Cc: Michael Eastham
Subject: Saltbox- Drainage

Thank you for your time this morning. As promised, below is a summary of the outstanding drainage issues/ my comments.

CLIENT	LANDLINK ESTATES		
PROJECT	SALTBOX BOGNOR REGIS		
TITLE	ACCESS ROAD DRAINAGE LAYOUT SHEET 1		
HYDROCK PROJECT NO.	C-13319-C	SCALE @ A1	1:250
STATUS DESCRIPTION	TENDER	STATUS	D2
DRAWING NO. (PROJECT CODE-ORIGINATOR-ZONE-LEVEL-TYPE-ROLE-NUMBER)	SAL-HYD-00-ZZ-DR-C-7020	REVISION	P05

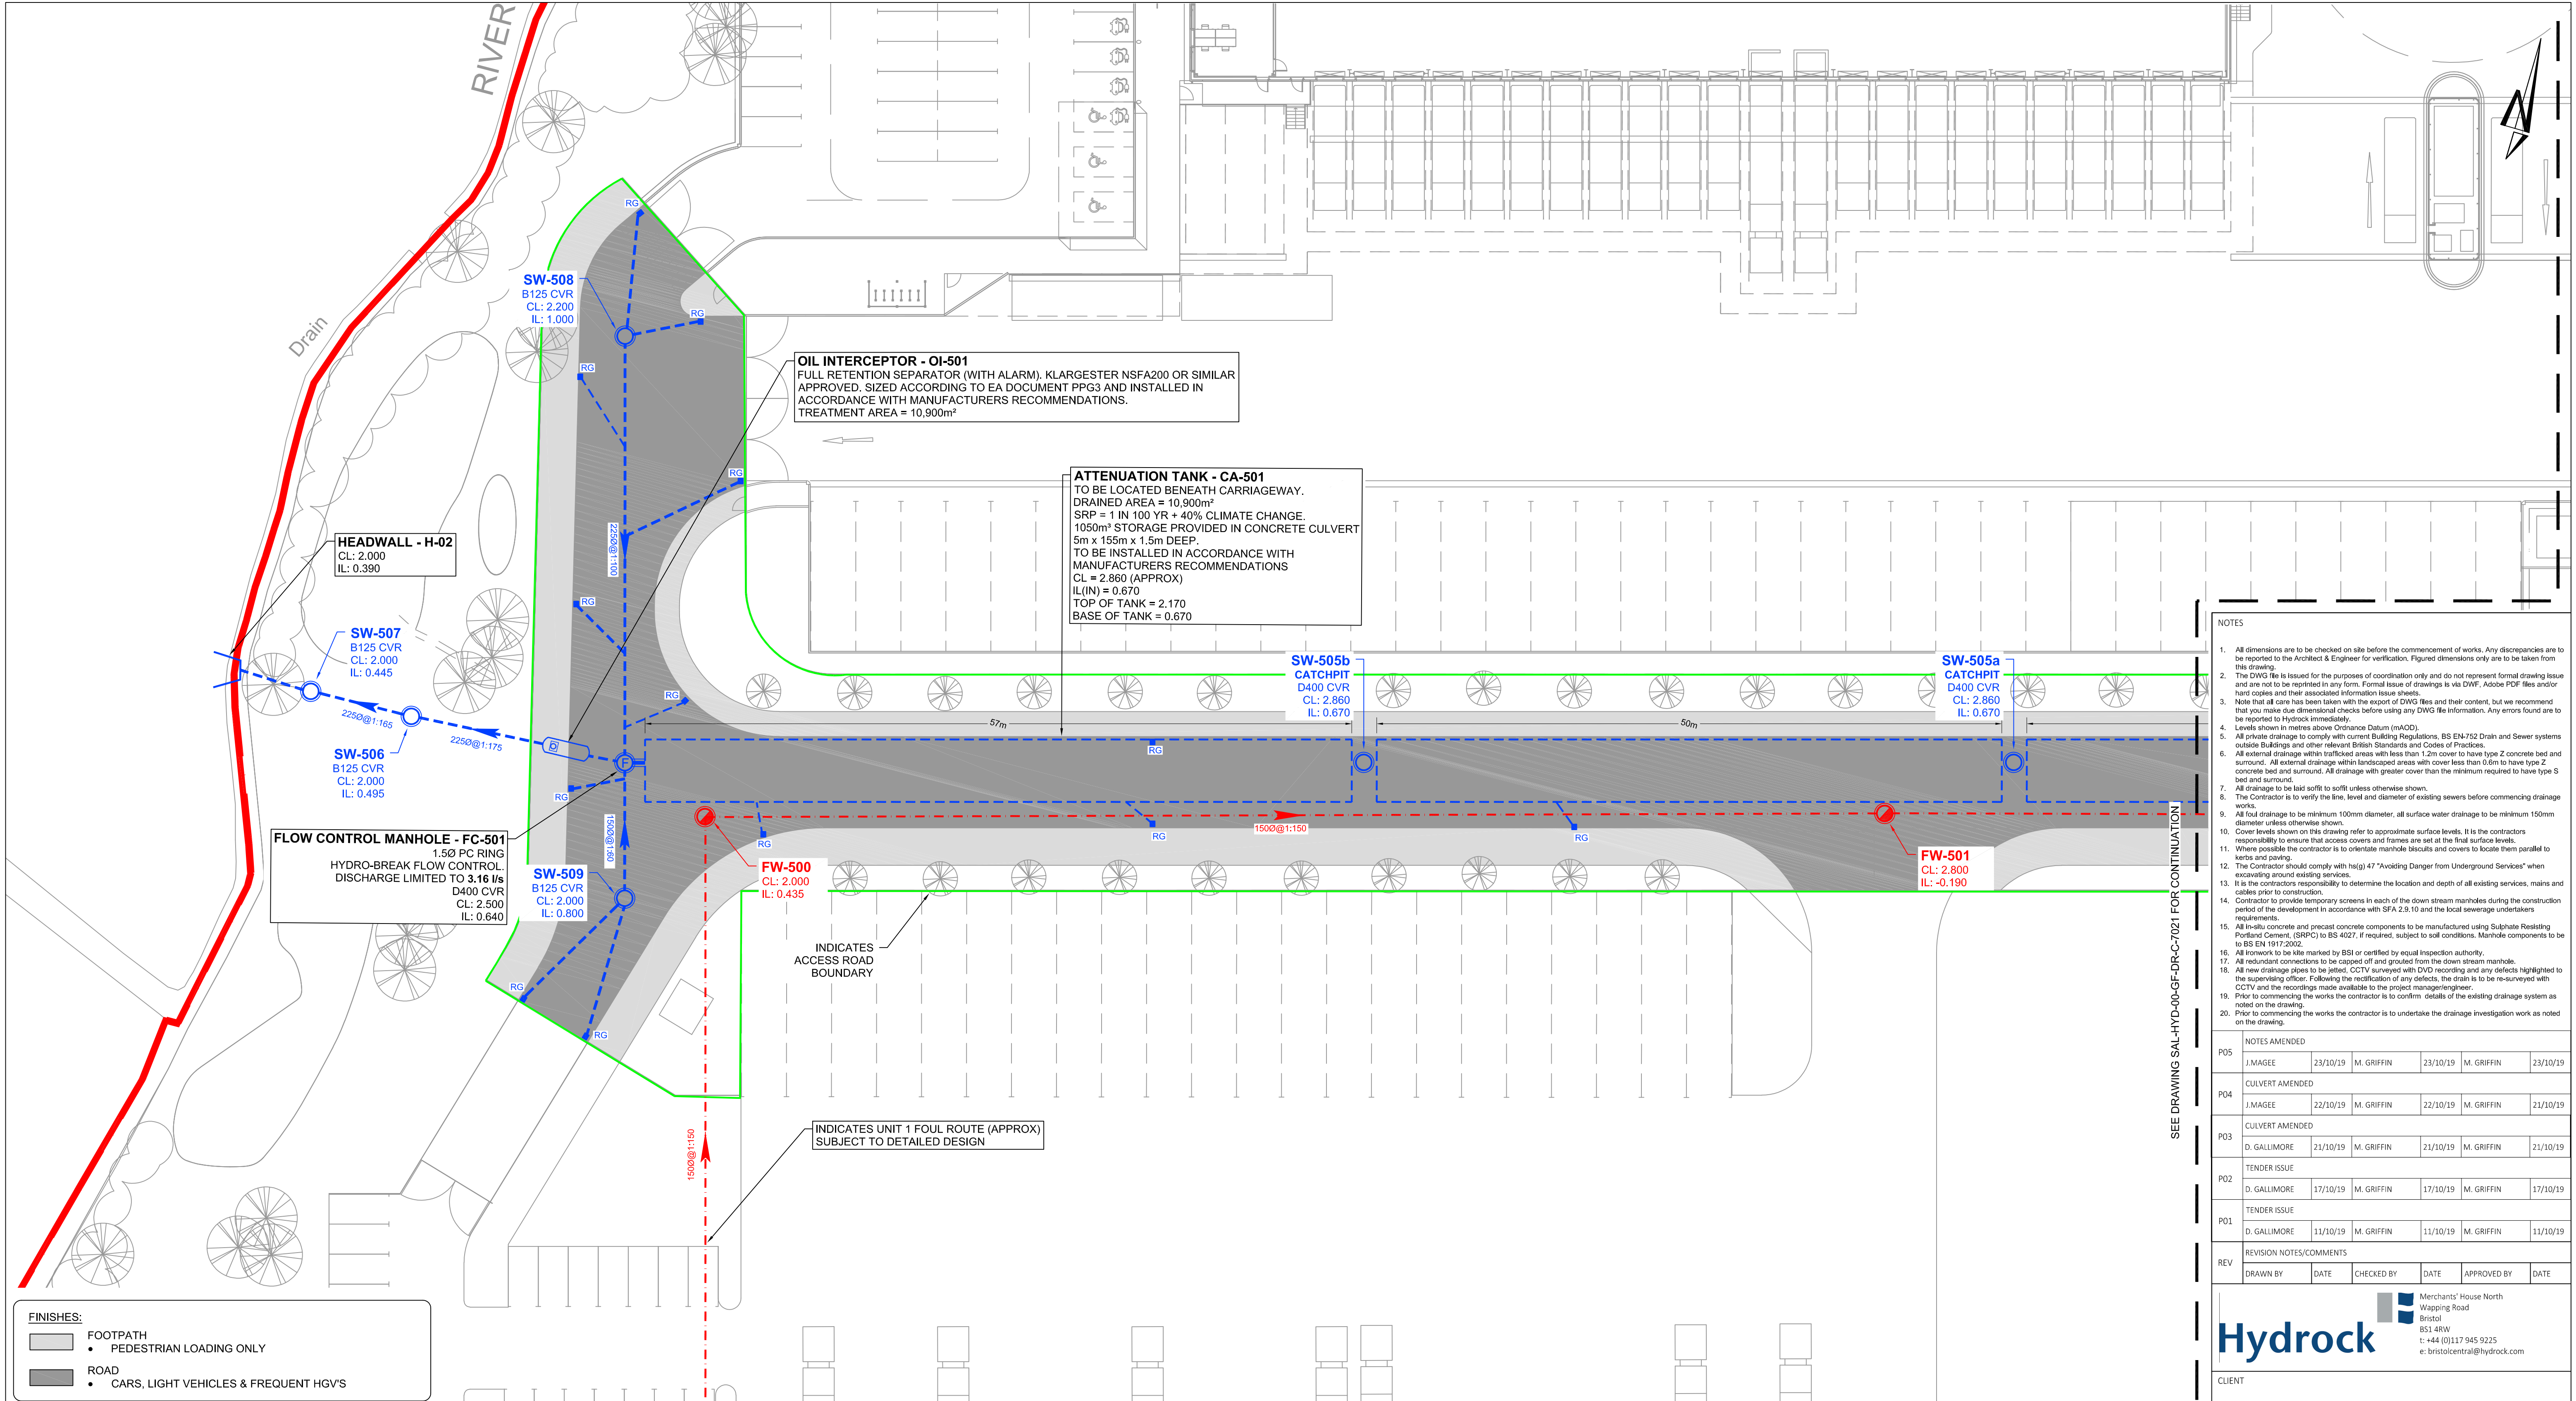
1. Shallow infiltration testing is going to be conducted at the depths and locations of potential permeable paving areas. If the results of this are $\times 10^{-6}$ or greater permeable paving should be implemented as part of the surface water drainage scheme. If it is demonstrated that half drain times exceed 24 hours for the 1 in 10 year plus 40% climate change event a high level overflow to the watercourse can be provided. We would expect this overflow to only come into use when water levels exceed the 1 in 100 year plus 40% climate change event levels. If it is demonstrated that infiltration rates are $\times 10^{-7}$ or less the original scheme should be taken forwards.

4. Confirmation will need to be provided that 8m easement is provided to the top of bank of main river, and 3m to the top of bank of ordinary watercourse.

5. I will need confirmation that the proposed outfall to the north is constructible given its proximity to overhead cables. If this cannot be guaranteed the outfall should be repositioned away from the overhead cables.

7. Full details must be submitted of how adequate treatment of surface water is to be achieved via the proposed surface water drainage scheme.
8. A maintenance manual should be submitted.
